# ETHOS URBAN

## Response to Public Individual Submissions

Redevelopment of Greenwich Hospital

27 September 2019 | 2190376

DRAWING TITLE:
SITE PLAN - OVERALL

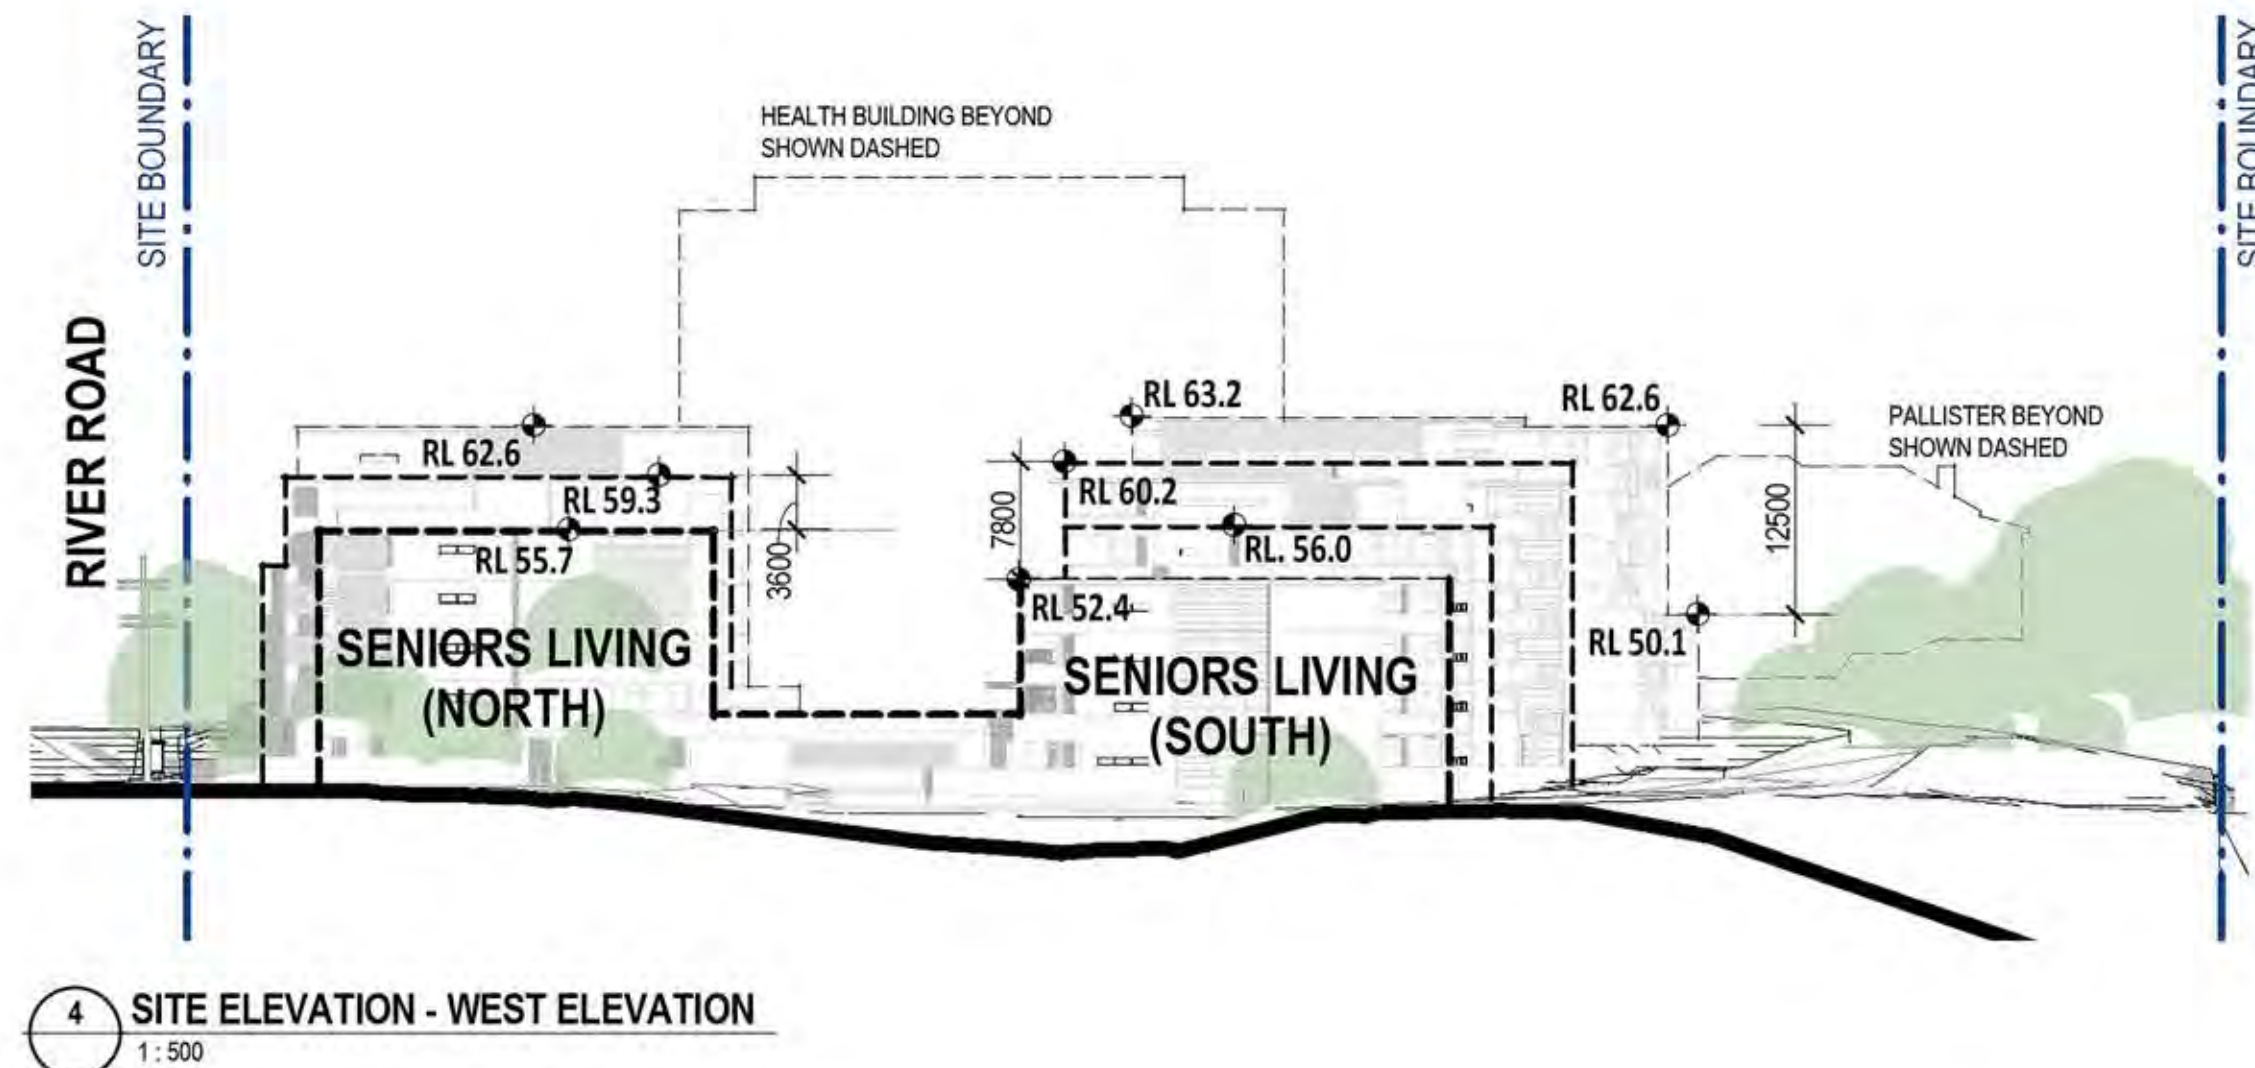
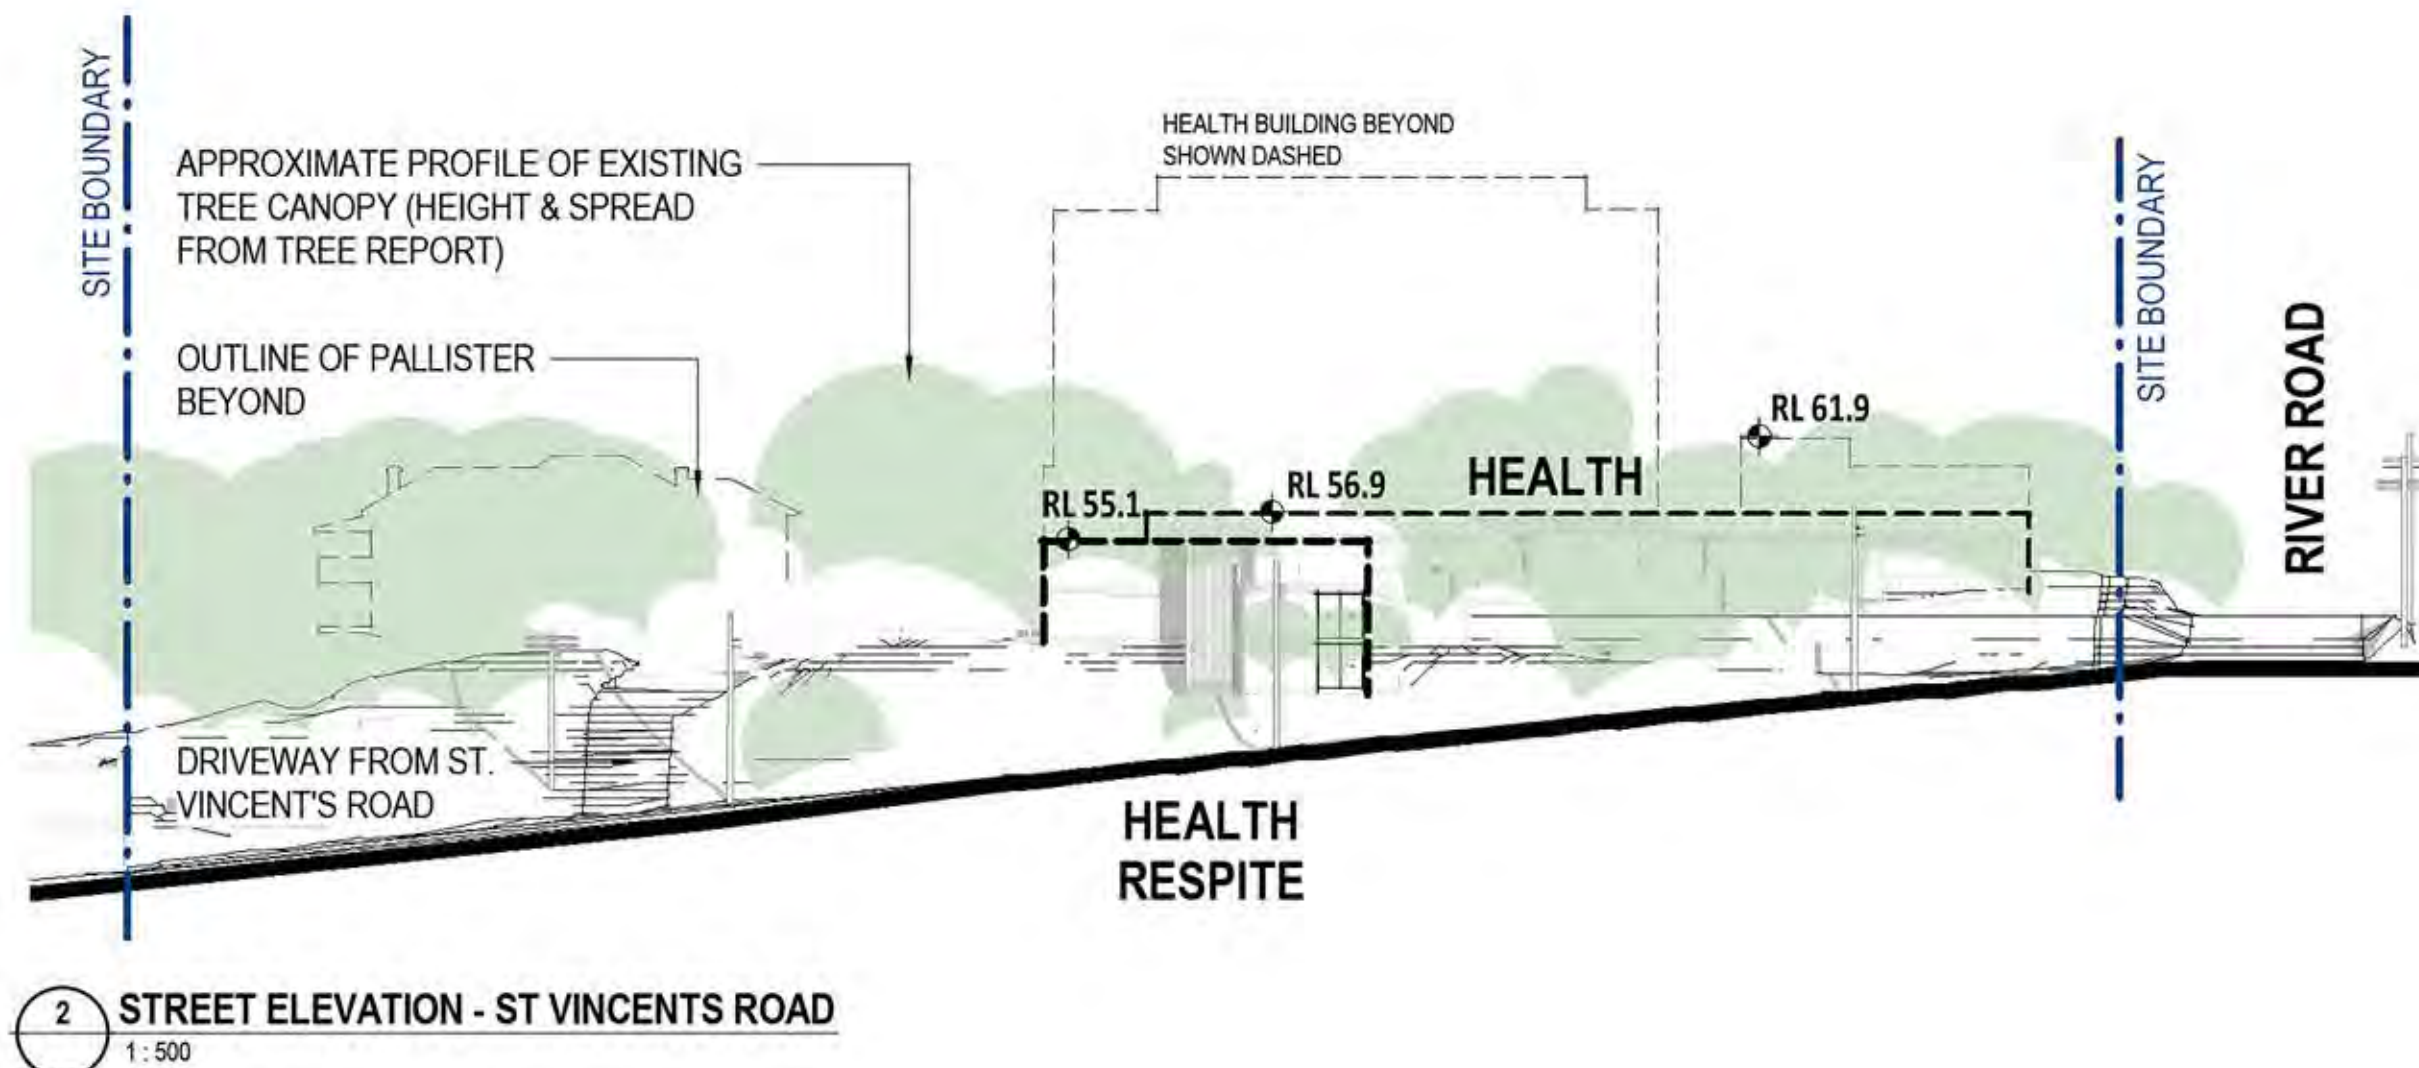
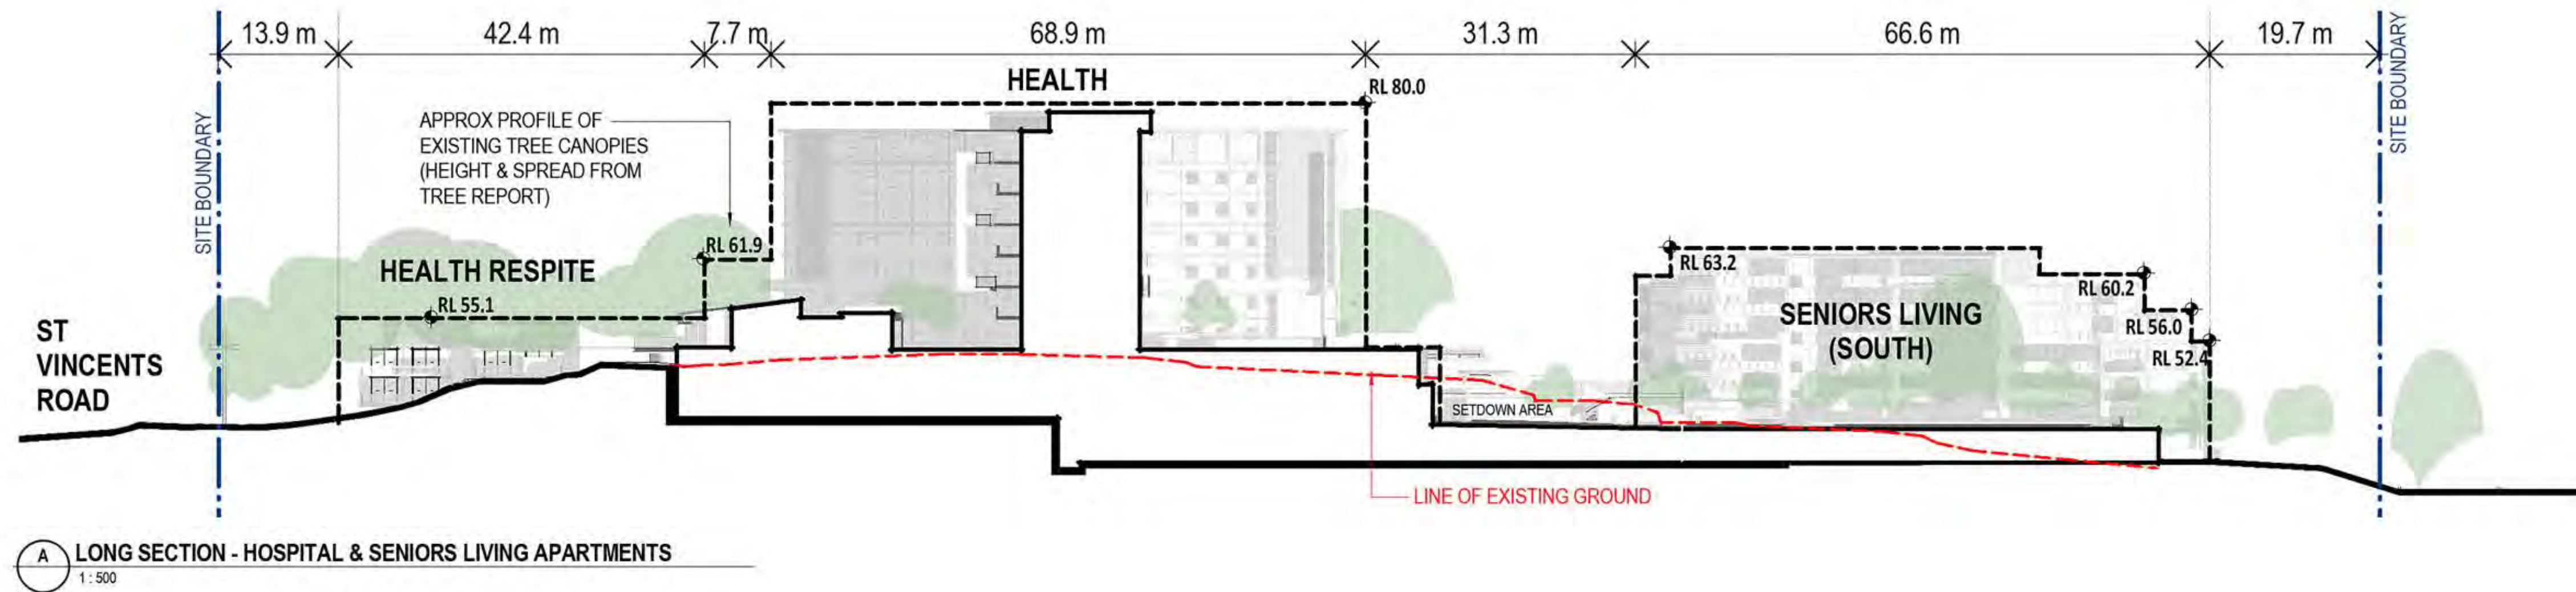
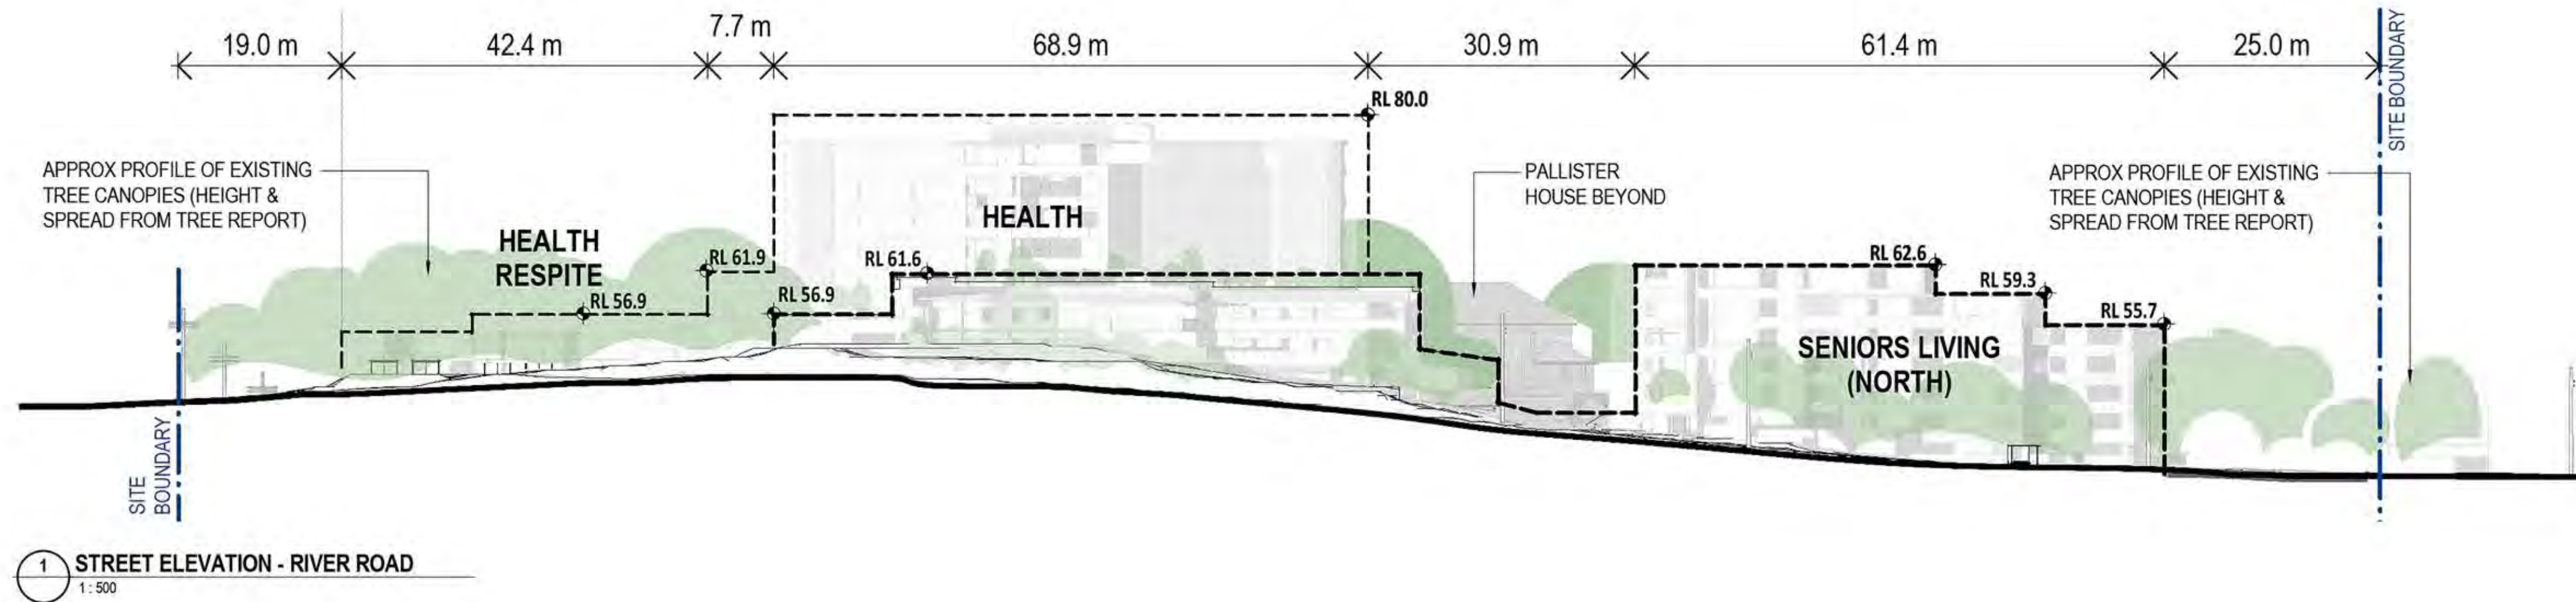
Bulk and scale of the Seniors Living uses are unsympathetic/out of place to the surrounding residential urban context	<p>Refer to <b>Section 2.2</b> of the RTS report. The overall bulk and scale of the seniors living buildings have been reduced in the revised scheme, from a GFA of 14,400m<sup>2</sup> as originally proposed to 13,000m<sup>2</sup> as modified. This has involved the removal of all Seniors Living Villas from the scheme and its replacement with a new Respite Care Facility, to better integrate with the primary Health Services use of the site.</p> <p>Furthermore, design changes have been made to reduce the visual impact of the seniors living buildings. The building envelopes, including the top floor levels, have been reconfigured and reduced to soften its appearance and reduce visual bulk. The southern building now steps down to provide a smaller backdrop to Pallister House, whilst the northern building envelope has been reduced at its western end to step down to the neighbouring lower scale residential buildings. The revised design is shown in detail in the Amended Architectural Plans provided by Bickerton Masters at <b>Appendix A</b>.</p>	66

Loss of visual amenity from Northwood	The proposed design changes will minimise the loss of visual amenity from Northwood, including through a reduction in the size and scale of the proposed seniors living buildings to better integrate with surrounding built forms to the west of the site, and increasing the setbacks to the western boundary by approximately 5m and stepping down the façade of the building at this interface to reduce the perceived bulk from the public domain and immediate neighbours. This issue is further addressed at <b>Section 2.2</b> of the RTS report.	21
Overdevelopment of the site	The revised design reduces the scope and scale of the proposed redevelopment and incorporates design changes to better integrate the built form with its surroundings. This involves a reduction in seniors living uses from 14,400m <sup>2</sup> as originally proposed to 13,000m <sup>2</sup> as modified, and the removal of the Villas to be replaced by a Respite	27
